Our Ref: A/112/12/

13th December 2012

Rear decking and fencing to form outside seating area
Lamb Inn The Square Angmering Littlehampton

PROPOSED BLOCK 1:200

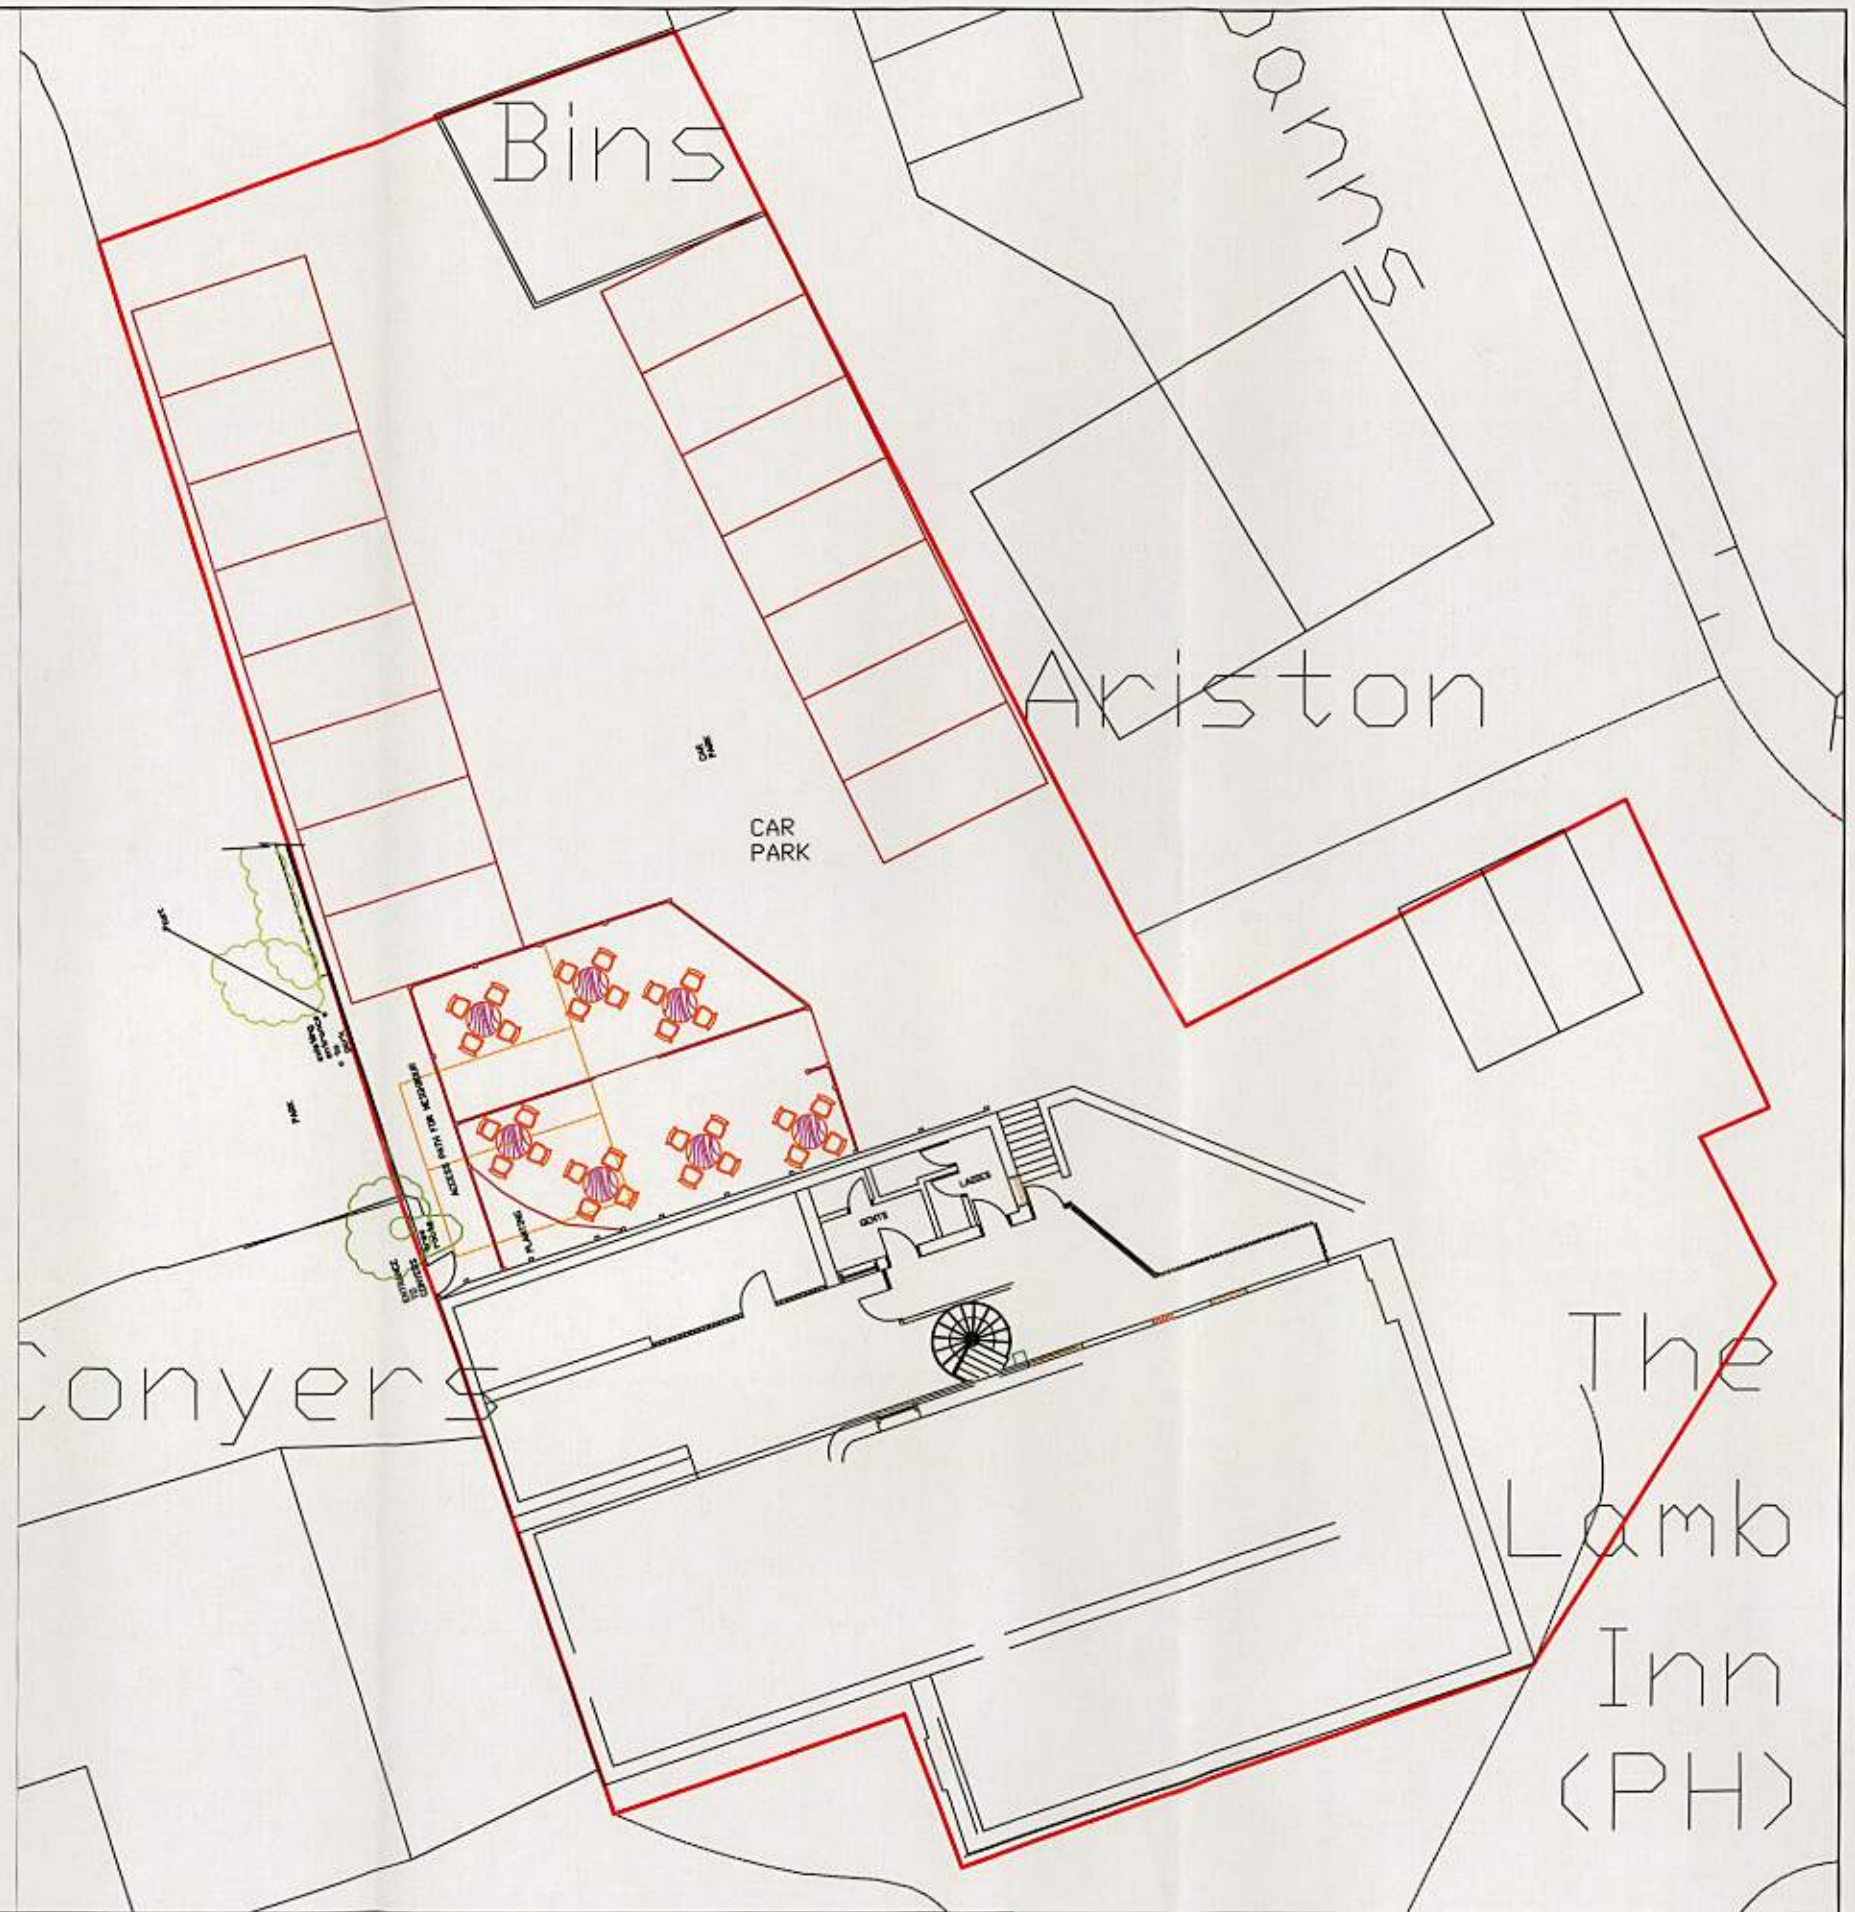
No objection. The gap between the fencing and first parking is to be sufficient.
